**Subject:** 2025/90956 at location Moorlands Cricket Club, Mirfield Memorial Park, Huddersfield Road, Mirfield, WF14 8AE

Please see ecological commentary below:

Pre-Development Plan Baseline Map

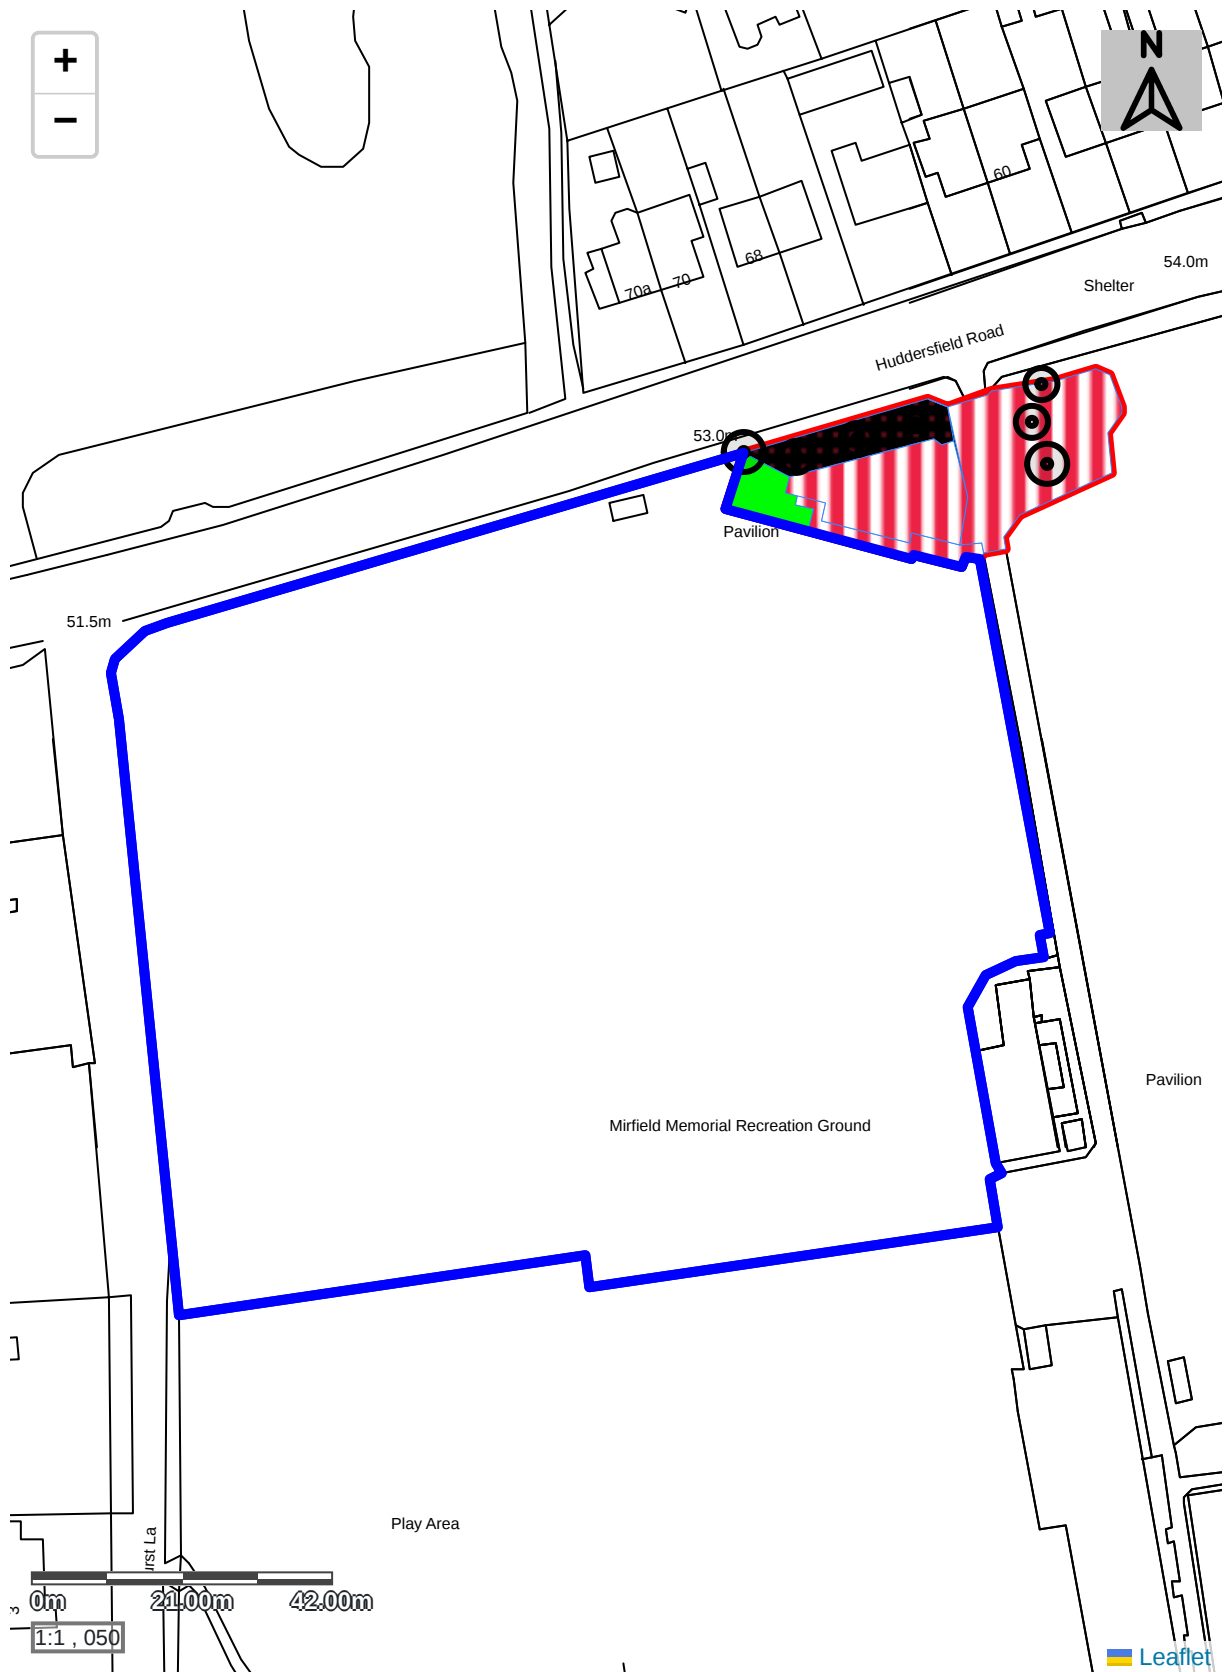
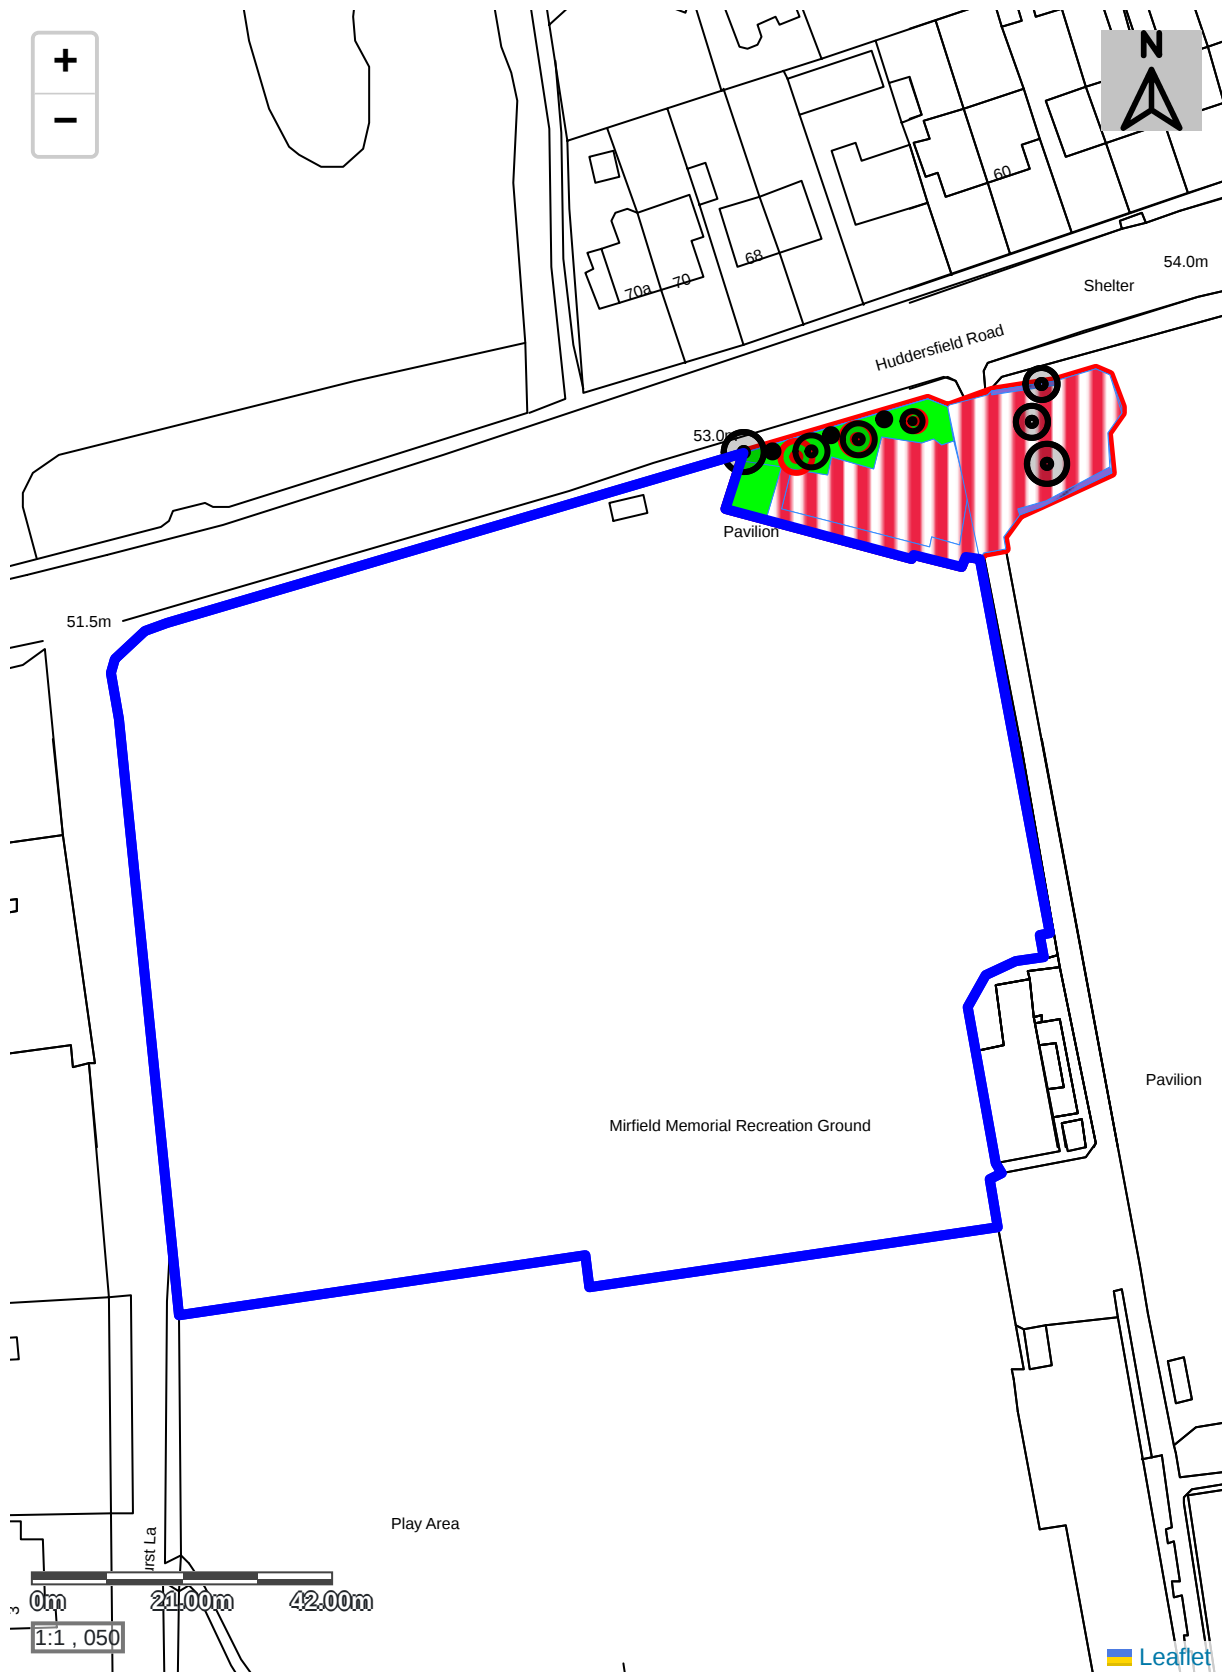
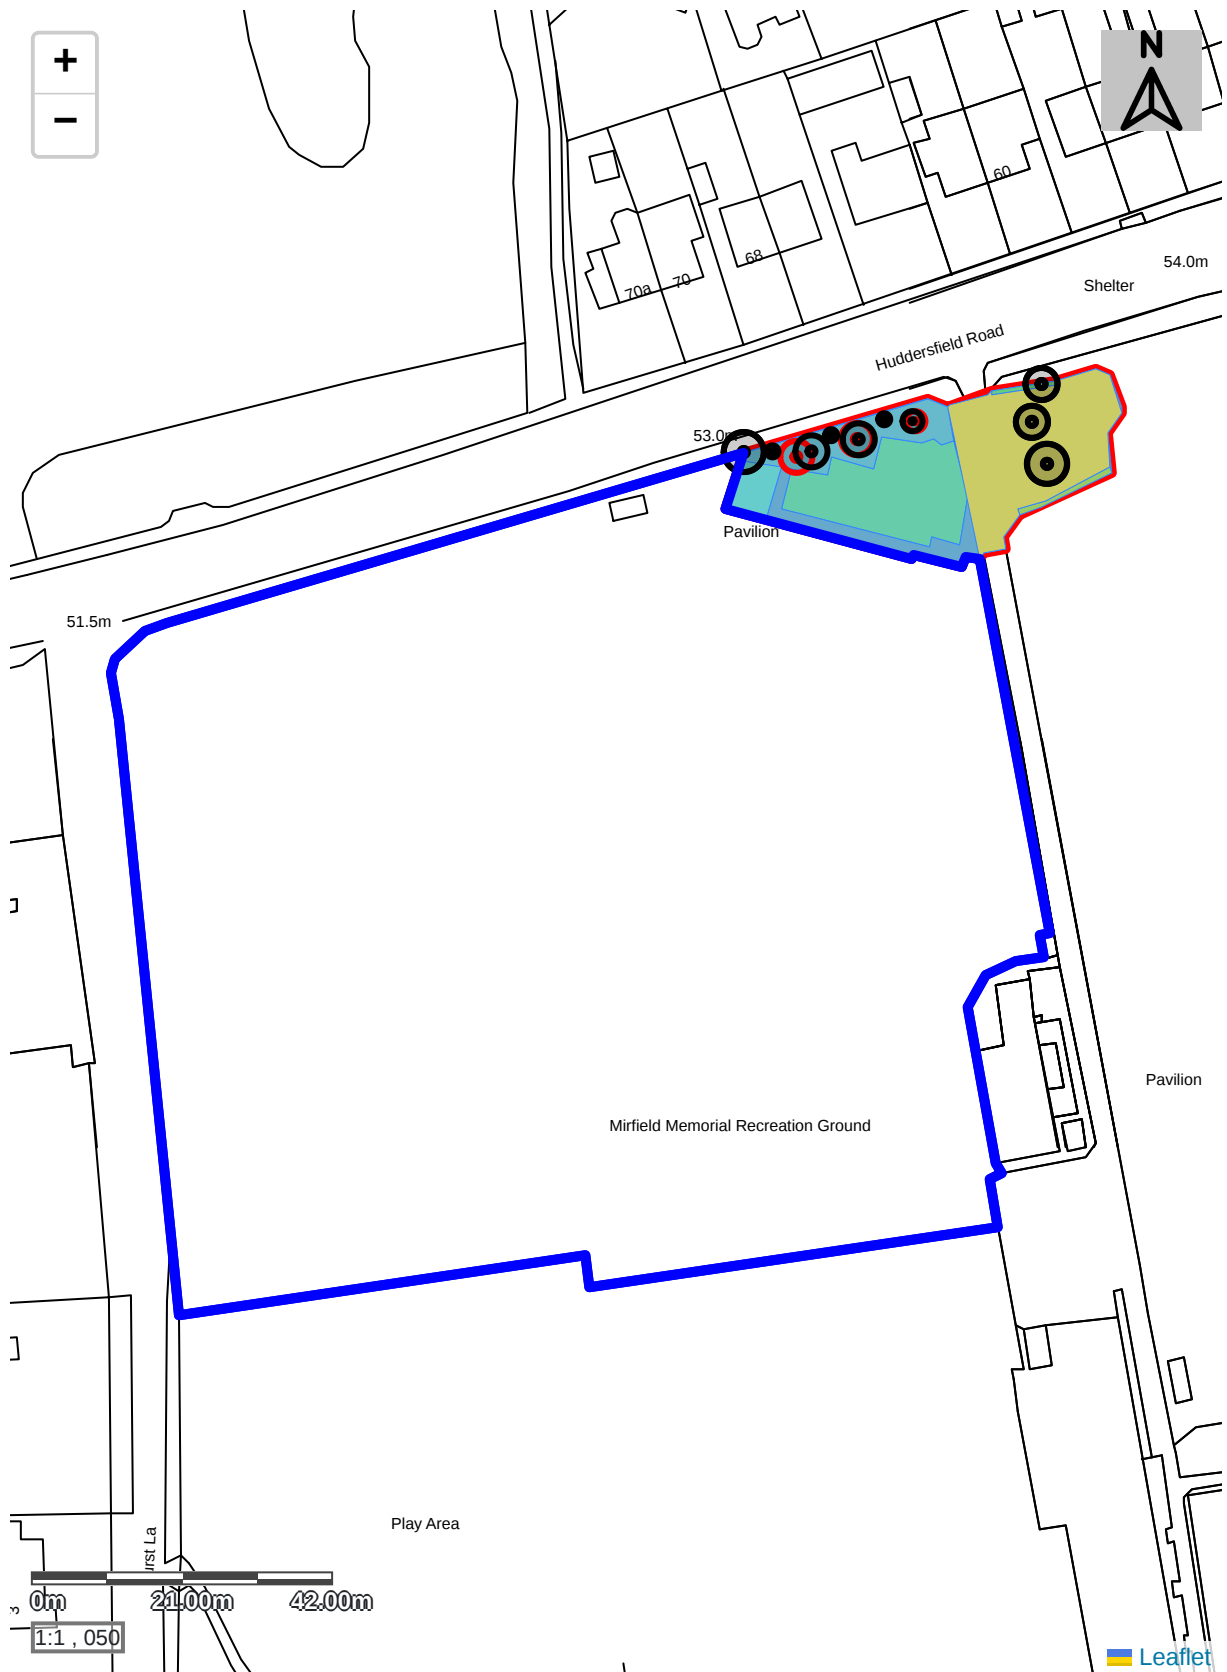
The metric provided (Elliot Cooper (Junior Design Assistant), March 2026) has been provided. There will be an onsite net gain of 0.1789 habitat units with the creation of low – medium distinctiveness. We consider that the onsite element of the BNG proposal will not result in significant onsite gain as it would be delivered by. This does therefore not need to be secured for 30 years but could be secured by a simple landscaping condition, if appropriate, to ensure it is provided and maintained for an aftercare period.
